37 Archer Street, Chatswood – Response to DPHI Key Issues Letter (REF: SSD-73277714)

This letter has been prepared to response to the DPHI Key Issues letter (REF: SSD-73277714) and the request for additional information for the SSDA submitted for 37 Archer Street, Chatswood. As part of the DPHI Key Issues, comments were provided from NSW SES and Willoughby City Council including Council's consent conditions. This letter will address each flood related item which requested additional information.

Flood Impact & Risk Assessment Report

Title:
Proposed PMF Flood Hazard

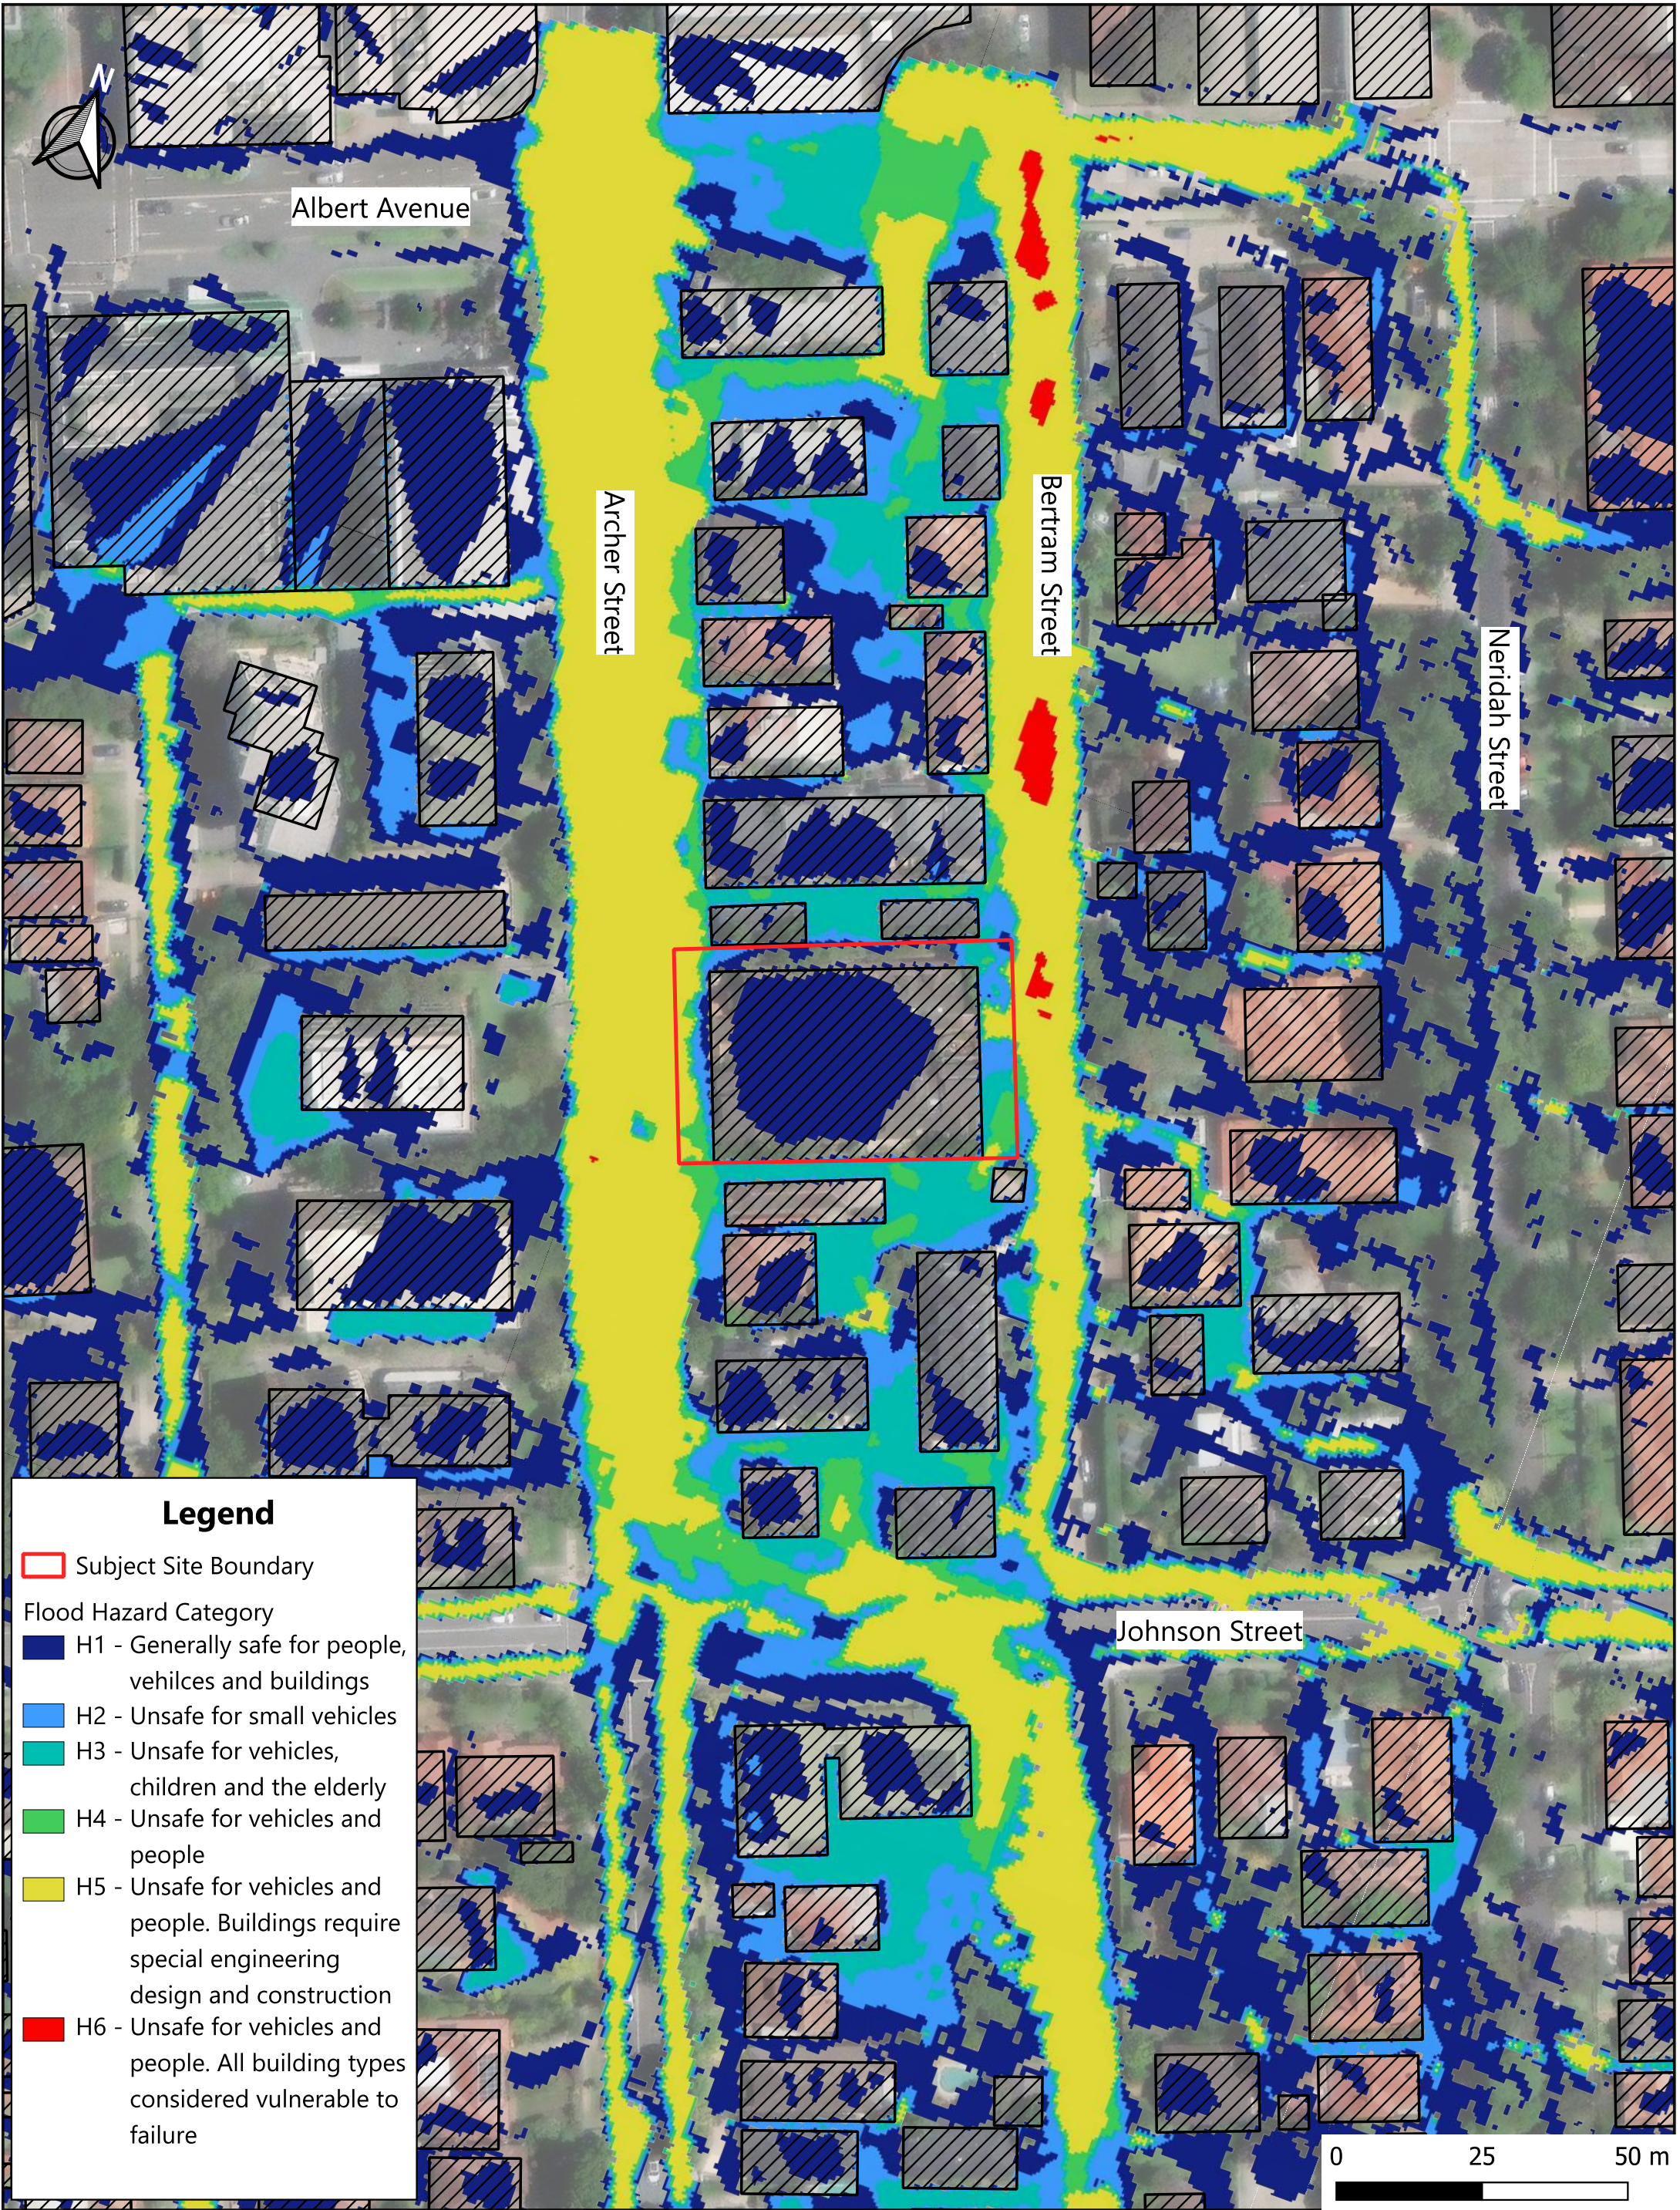
Item 2: NSW SES recommend careful consideration of the suitability of reliance on the proposed Shelter-in-Place strategy for the site. As the site itself, as well as surrounding roadways are inundated by H5 flooding during the PMF, with little warning time available, this may pose a risk to the occupants. This site may not satisfy Shelter-In-Place consideration 8(c) of the Shelter-In-Place guideline.

Please refer to Section 6.8 of the FIRA where we have outlined how the site generally meets the shelter in place requirements. While we note that the surrounding roadways are inundated by H5 flows during the PMF storm event, this is due to the steep grades of Archer Street and Bertram Street and an overland flow route through each roadway.

To assess the nature of flooding further, time of inundation additional mapping of the PMF storm event was prepared (shown in Appendix A of the FIRA). This map identifies the duration of time that the flood waters are greater than 150mm in depth.

This map shows that the longest time any of the surrounding roadways are inundated by the PMF storm event is 6 hours (and for the most part associated with ponding between buildings and not flows along the road reserves). As these are less than 12 hours, the flooding falls under the flash flooding category.

As such, a shelter in place strategy is an appropriate flood management response. It should be noted that the proposed site is situated above the PMF, with the access driveway crest level also set at the PMF level. The entire development site is protected from all storm events. Further, it is consistent with, and meets all other shelter in place requirements as outlined below.
